**KIRKLEES METROPOLITAN COUNCIL
INVESTMENT & REGENERATION SERVICE**

Reference No:	2025/62/90687/W
Site Address:	125, Crosland Road, Oakes, Huddersfield, HD3 3PW
Description:	Erection of front porch extension
Recommending Officer:	Molly Storer

HOUSEHOLDER DELEGATED REPORT

Drawing:
Proposed Plans Plans

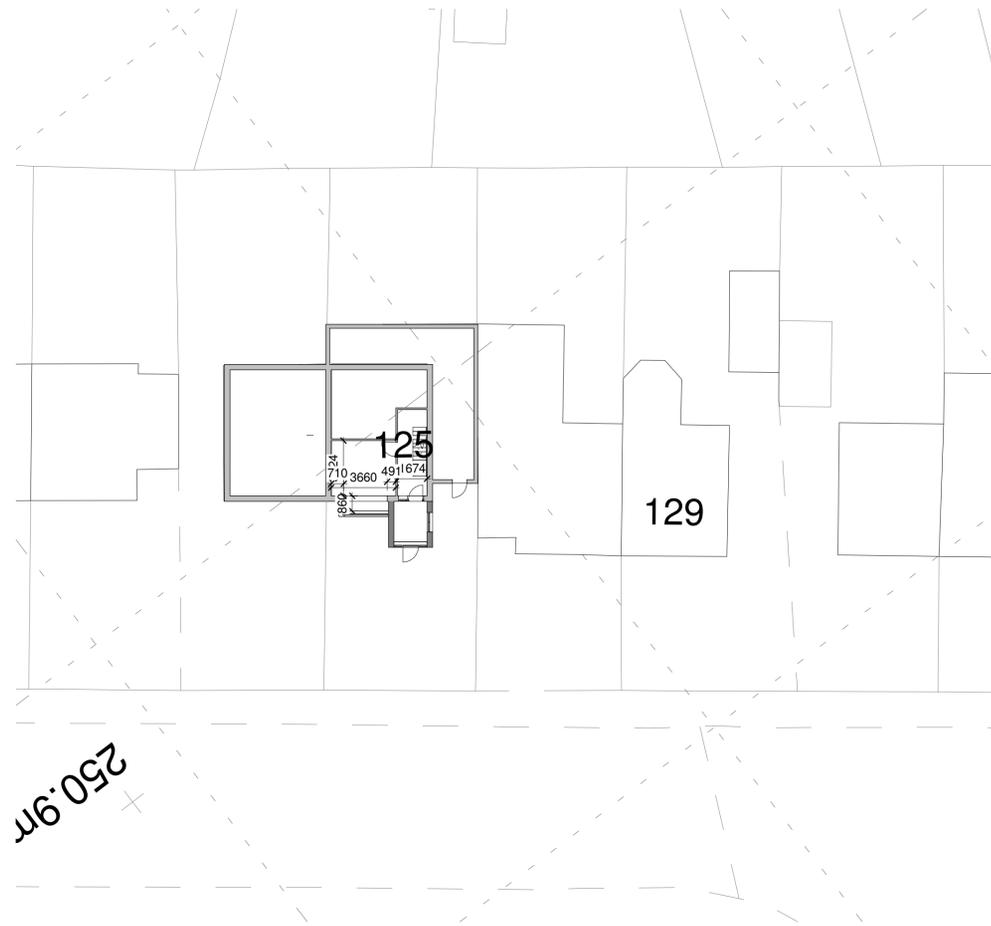
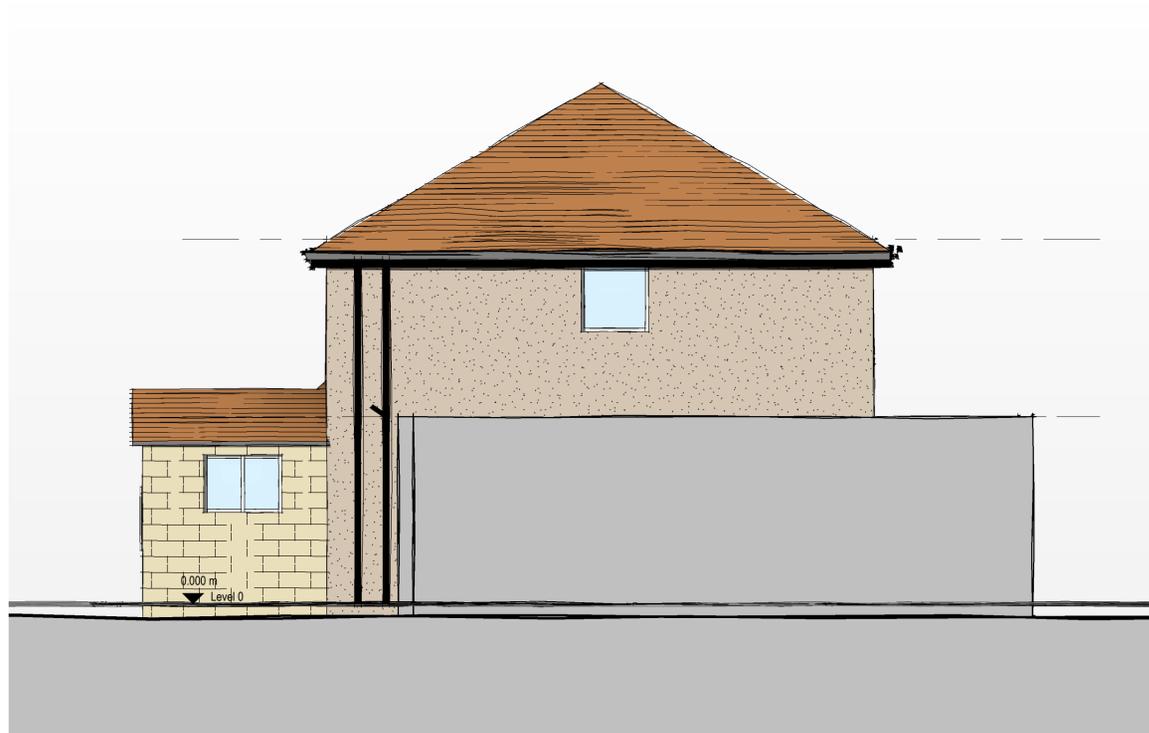
The front extension will have a 2.6m projection from the front and it will have a width of 2.5m. It would measure 2.45 meters to the eaves and have an overall height of 3.3m. it will have a gable roof design.

Relevant key design principle (KDP) of the SPD, Policy in the Kirklees Local Plan and the NPPF	Further comments	✓ / X / N/A
Impact on the Local character and street scene	• KDP1 of the SPD • Policy LP24 Design (a) and (c) of the KLP • Chapter 12 NPPF	Although the extension will face onto the street, with a projection of 2.6 meters it will be constructed from the same materials as the original dwelling. Weight is afforded the siting of the host property and in relation to no.27 which is set forward of the host property. As such the prominence of the proposal is reduced and its impact lessened by this siting. The individual site characteristics in this case lead to the conclusion that whilst of a size and scale which may not be suitable in differing circumstances, in this case refusal on the basis of impact upon the character of the locality / street scene could not be substantiated. Weight is afforded this as a justification for the fact the proposal would not comply with this element of the SPD in terms of being a small addition and the individual site characteristics are afforded weight in this case such that, on balance, the proposal is considered to be acceptable in this regard.	✓

It is therefore considered that the proposal will not cause material harm to the local character or street scene as the adjacent neighbours to the northwest are set forward of No.125. The front extension will not extend beyond the building line of No.129 & No.127.	
Impact on original house	• KDP2 of the SPD • Policy LP24 Design (c) and (d) of the KLP • Chapter 12 of the NPPF	Considered to be acceptable on the basis of being single storey and constructed from matching materials	✓
Height, scale and massing	• KDP 1 and 2 of the SPD • Policy LP24 Design (a), (c) and (d) of the KLP • Chapter 12 of the NPPF	This is considered to be acceptable having regard to the siting of the proposal to the front and subsequent impact to the locality / street as discussed above.	✓
Facing materials and detailing	• KDP 9 of the SPD • Policy LP24 Design (d) (iii) of the KLP • Chapter 12 of the NPPF	Materials to match- stone and render for the walls and tiles to match the existing roof. Condition recommended.	✓

Roof style	• KDP 1 and 2 of the SPD • Policy LP24 Design (a), (c) and (d) of the KLP • Chapter 12 of the NPPF	Gable roof design – although different to the original dwelling roof design it is considered due to its limited size this will adequately harmonise.	✓
Window proportions	• KDP 1 and 2 of the SPD • Policy LP24 Design (a), (c)	There will be one window located in the northwest elevation however this will look onto the blank wall of a garage at the	✓

and (d) of the KLP • Chapter 12 of the NPPF	neighbouring property. There will be an opening in the front elevation. The openings are considered to be acceptable in terms of their design.	
Accessibility for all users	• KDP 17 of the SPD • Policy LP24 Design (f) • Chapter 12 of the NPPF	Private domestic extension – no alterations to general access arrangements	✓

There will be no windows facing in the direction of this property therefore privacy will not be significantly impacted. The extension will be set well within the site boundary and will have a separation distance of 3.5m to the boundary with this property. In any case the existing bay window will provide some level of screening with the extension only projecting 1.74m in light of this. Therefore it is considered there would be no significant overlooking/overbearing impact to this neighbour.

Relevant key design principle (KDP) of the SPD, Policy in the Kirklees Local Plan and the NPPF	Further comments	✓ / X / N/A
Impact on privacy of neighbours (to sides, rear and front)	• KDP 3 & 4 of the SPD • Policy LP24 Design (d) (iv) • Chapter 12 of the NPPF	Although there will be a window in the elevation facing this property as No.127 is set forward of No.125 this window will face a blank elevation of the neighbours garage therefore there will be no	✓

significant harm to privacy.	
Impact on light and outlook of neighbours (to sides, rear and front)	• KDP 4, 5, 6 of the SPD • Policy LP24 Design (b) • Chapter 12 of the NPPF	Due to the scale of the extension and the differing building lines of the houses there will be no significant impact on light or outlook of the neighbouring properties.	✓
Impact on overbearing or overshadowing	• KDP 5, 6 of the SPD • Policy LP24 Design (b) • Chapter 12 of the NPPF	As the property at No.127 is set on a building line which is forward this means that the proposal will not be significantly overbearing or overshadow this dwelling. It is also set sufficient distance away (2.6m) from the proposed extension and therefore will not cause any material harm.	✓
Remaining garden space of application property	• KDP 7 of the SPD • Policy LP24 Design (b) and (c) • Chapter 12 of the NPPF	Acceptable level of remaining garden space	✓

3. The external walls and roofing materials of the development hereby approved shall in all respects match those used in the construction of the existing building and be retained thereafter.
